MONUMENT GLAMPING SITE PLAN
16315 RICKENBACKER AVE.
MONUMENT, CO 80132

SITE PLAN

SITE PLAN

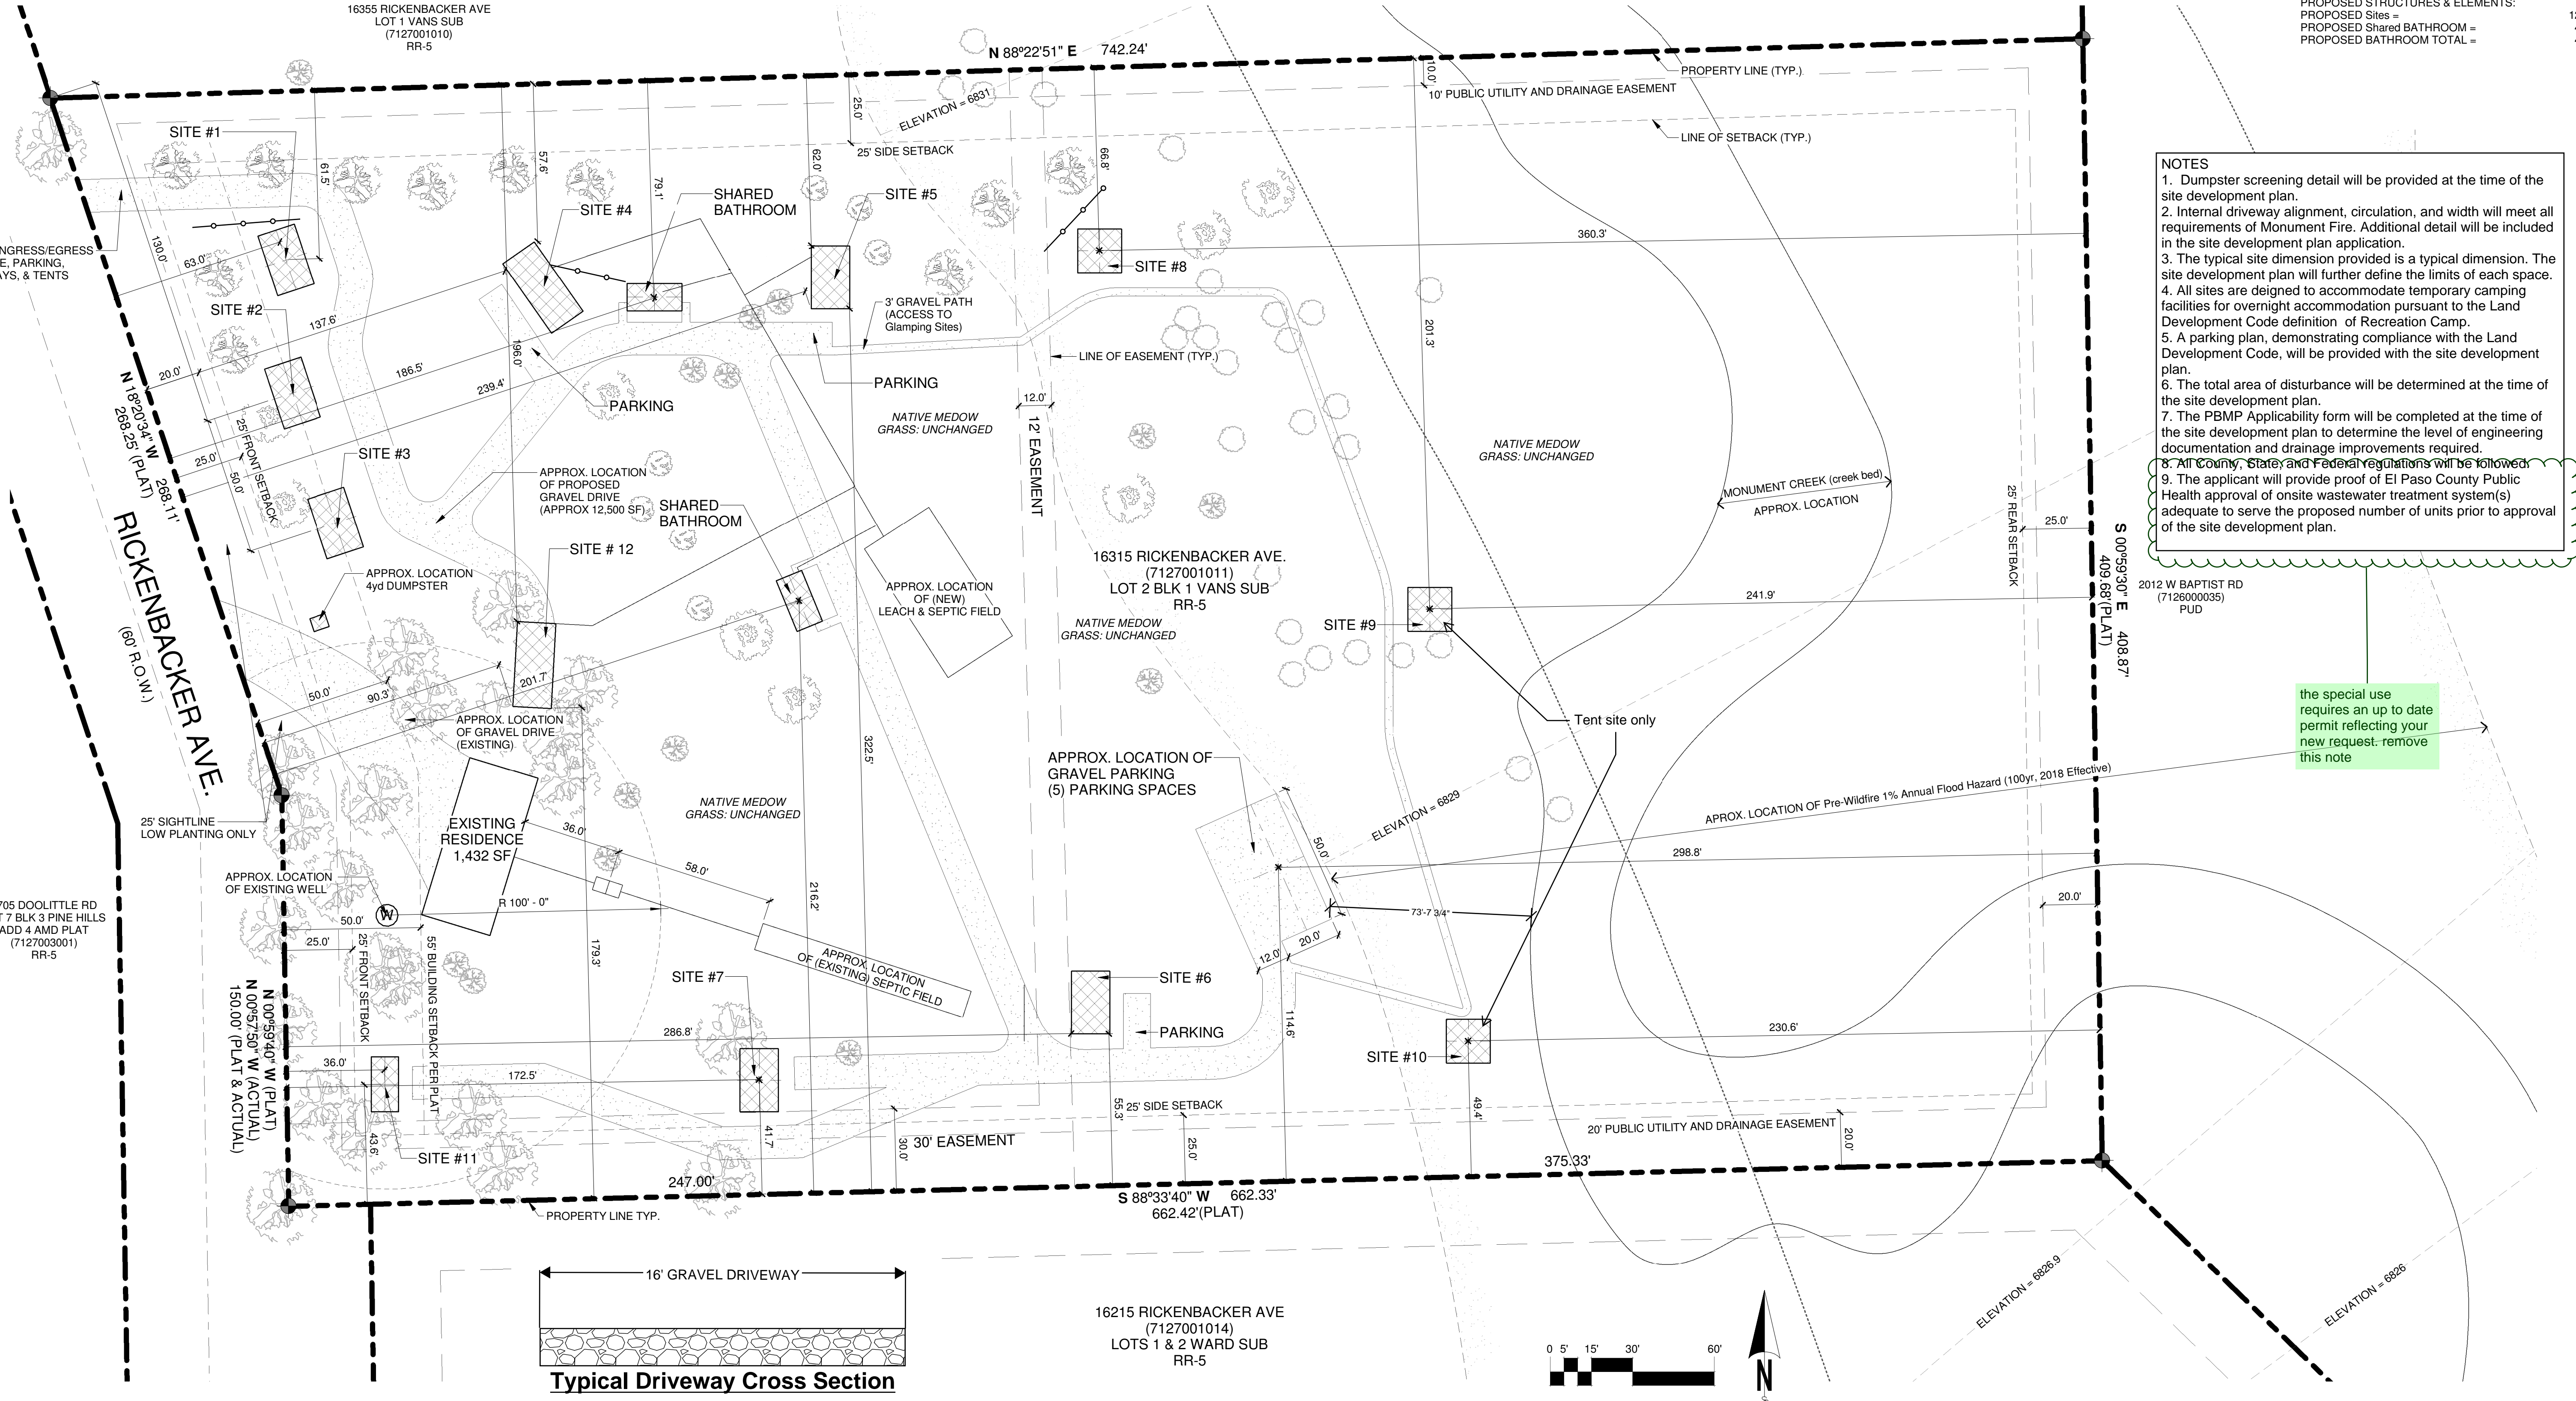
Someone in support discussed the 3 new sites you will have at the property and how they will be on wheels. It is imperative that you are transparent with this application about the changes/ modifications you are proposing. Thus far, you have not depicted these modifications as discussed in prior meetings and emails and it is holding up the project.

UNRESOLVED V1 COMMENT:
Please specify the style of sites
ex:
tent
RV

UNRESOLVED V1 COMMENT:
Please include:
-RV site and number of those sites
-shipping container on the site and its use
-specify what each site is, ex: "tent", or "rv"
